23/03428/OUT - Outline planning application for the construction of up to 140,000 sqm of employment floorspace (use class B8)

The Banbury Civic Society wishes to make the following comments following the submission of OCC's objection to the above application.

JOB TITLE		LAND AT M40 J11		CLIENT		GREYSTOKE	
DRAWING TITLE							
A361 ROUNDABOUT WITH SECONDARY ACCESS							
SCALE	DRAWN BY	DATE	DRAWING No	REVISION			
1:1000@A1	RM	04/12/23	23457-07-01GA	C

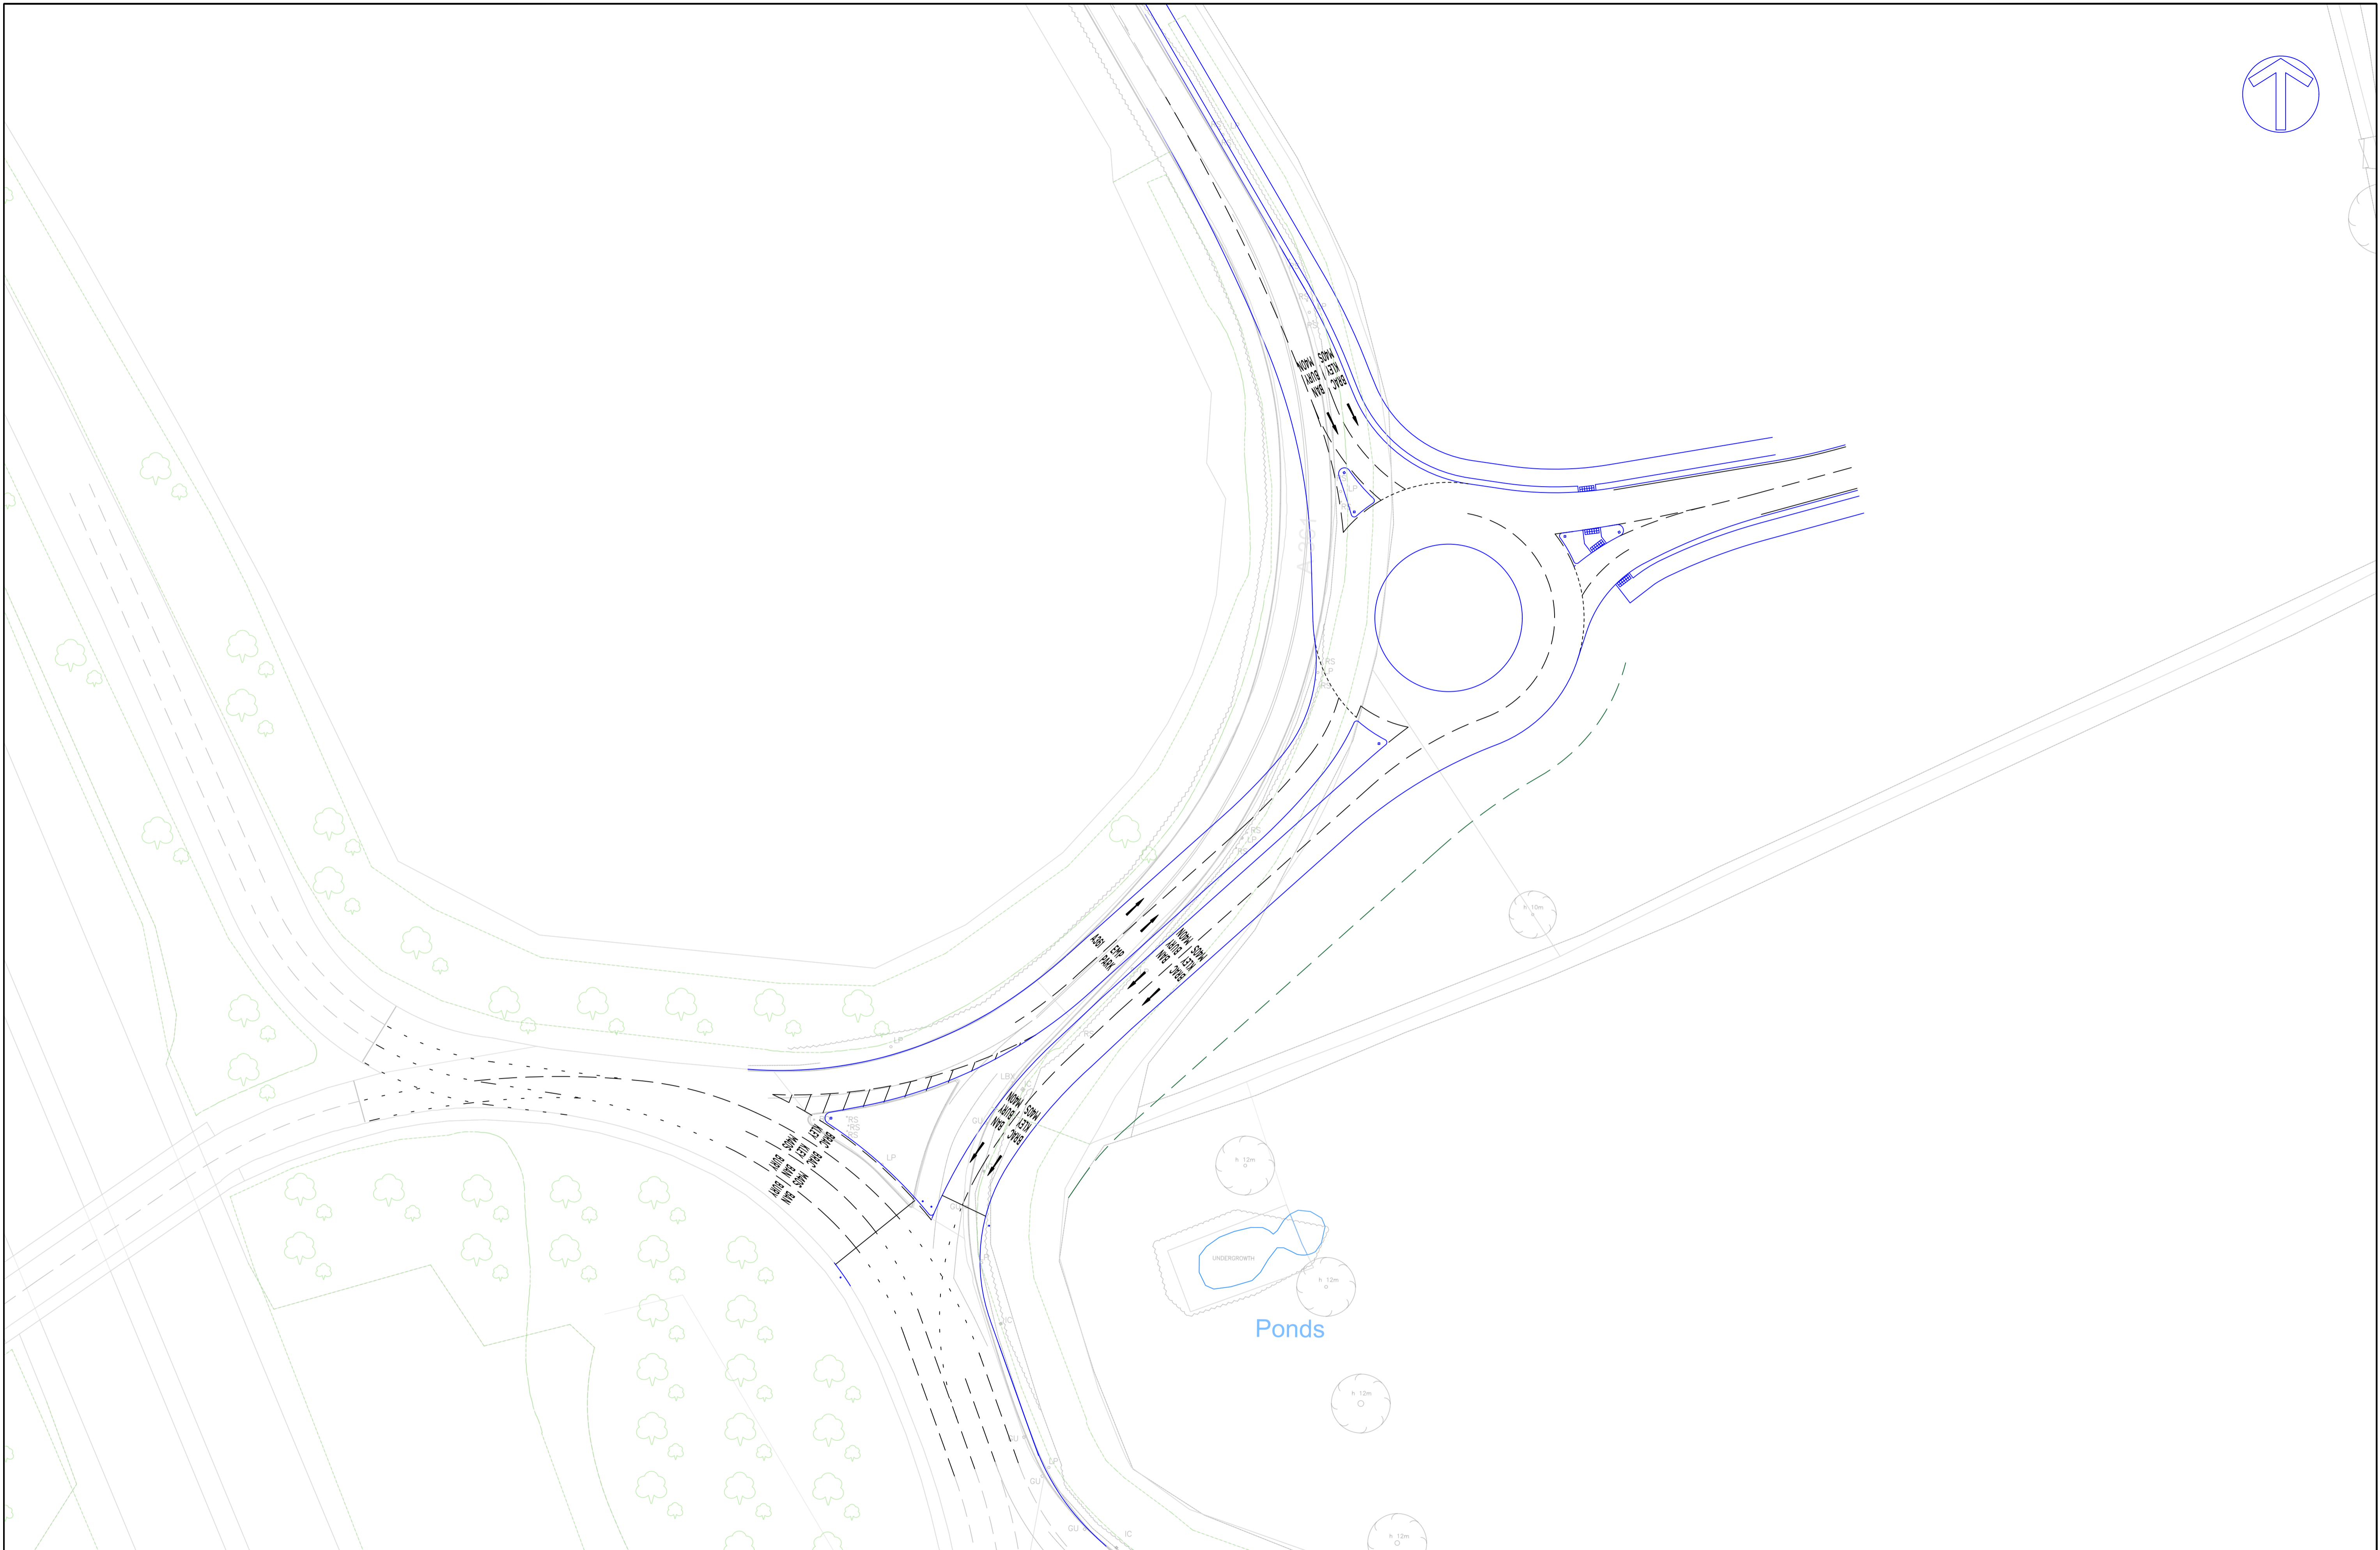
- *The site is in an unsustainable location for walking and cycling.*
- *The proximity of the access roundabout to M40 Junction 11 is likely to lead to severe congestion and potential safety issues arising from queuing on the M40 off slip.*

- *Based on the current modelling results, the proposed signalisation of the A361 does not mitigate the impacts of development.*
- *It has not been demonstrated that a signalised crossing of the A361 for pedestrians and cyclists may be incorporated at a safe and suitable location, and an appropriate access into the site is not proposed.*
